TfNSW Reference: SYD21/00799/02

Client Reference: SSD-23330227

EXHIBITION OF EIS - UPGRADES TO JOHN PALMER PUBLIC SCHOOL AND INCREASE IN STUDENTS FROM 943 TO 1012 - 85 THE PONDS BOULEVARD, THE PONDS

Figure 3.2: Proposed pedestrian works concept

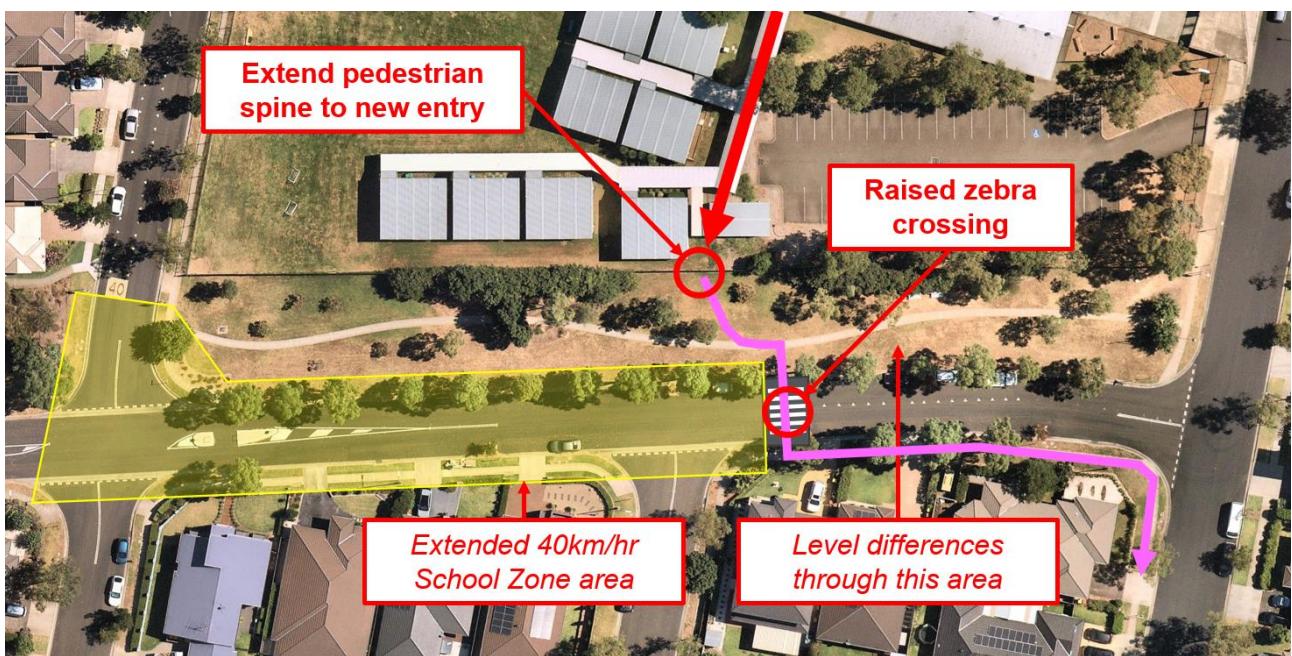
1. It is understood that the location of the proposed raised zebra crossing on Jetty Road is not yet confirmed. TfNSW provides the following comments for the further design and location of the raised zebra crossing design:

- TfNSW is concerned with regards to the sight distance at the approaches to the new raised zebra crossing due to in-lane plant box on Jetty Road.
- Safety concerns raised with regards to the location of the new pedestrian entry to the school location opposite to Sail street. This location may encourage pedestrian to cross at the intersection. Pedestrian fencing should be provided to ensure pedestrian crossing at the designated crossing facilities.

- The indicative location of the new raised zebra crossing on Jetty Street will conflict with the start of the existing 40km/h school zone.
- Once the confirmation of the exact location of the new access to the school is received TfNSW will conduct on site review in line with the School Zone Guidelines. Once the construction new entry is completed on site, the developer should allow 15 weeks between the construction completion date and the opening date for the school to allow TfNSW to review/approve/implement the extension of the 40km/h school zone signs.

- The new raised zebra crossing and associated signage will need to be submitted to and approved by the Local Traffic Committee prior to the construction.

Figure 3.3: Staff bicycle storage and end-of-trip facilities

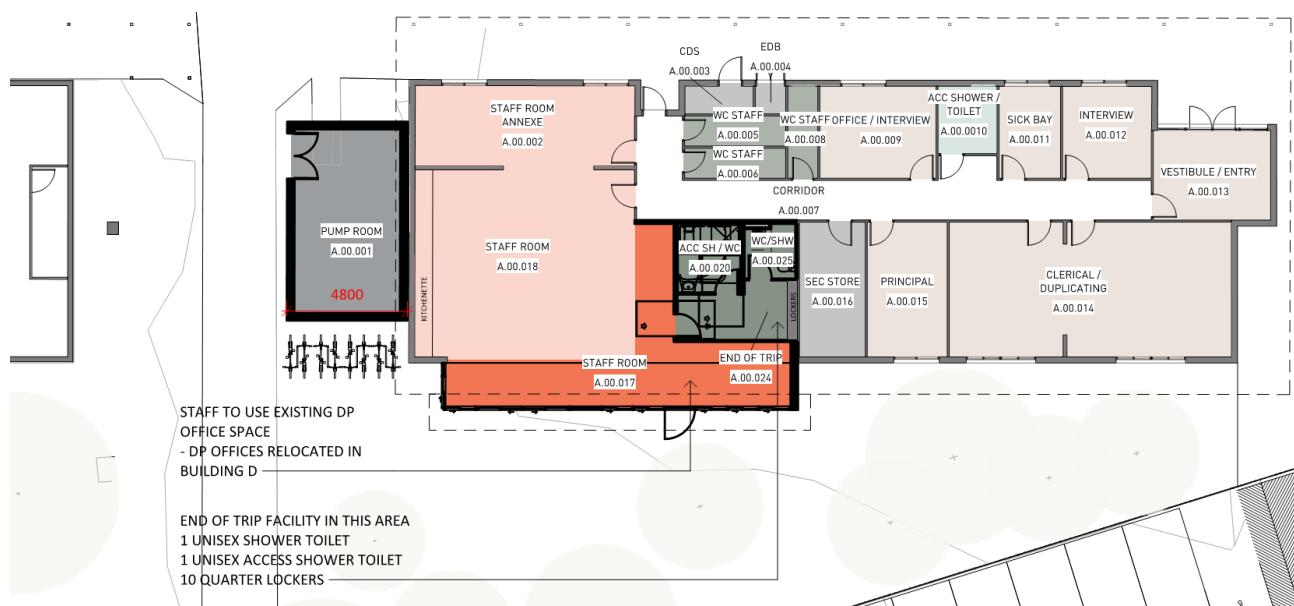
- Students and staff are re-moding private vehicles to buses.
 - Traffic volumes during peak hours had reduced.
- **End of trip (EOT) facilities** – Given the increase in student and staff numbers, and hotter temperatures in summer, it is recommended that the numbers of showers should be increased to **4** showers and **2** change rooms **in** total. This would mean 2 x showers plus 1 x change room for staff and the same amount for students. It is also recommended that the number of bike railings for staff should be increase. These facilities should be promoted within your “**Implementation Strategy**”. End of Trip Facilities Guidance can be accessed from the website on <http://data.mysydney.nsw.gov.au/Travel+Choices/EOT+Guidance.pdf>.
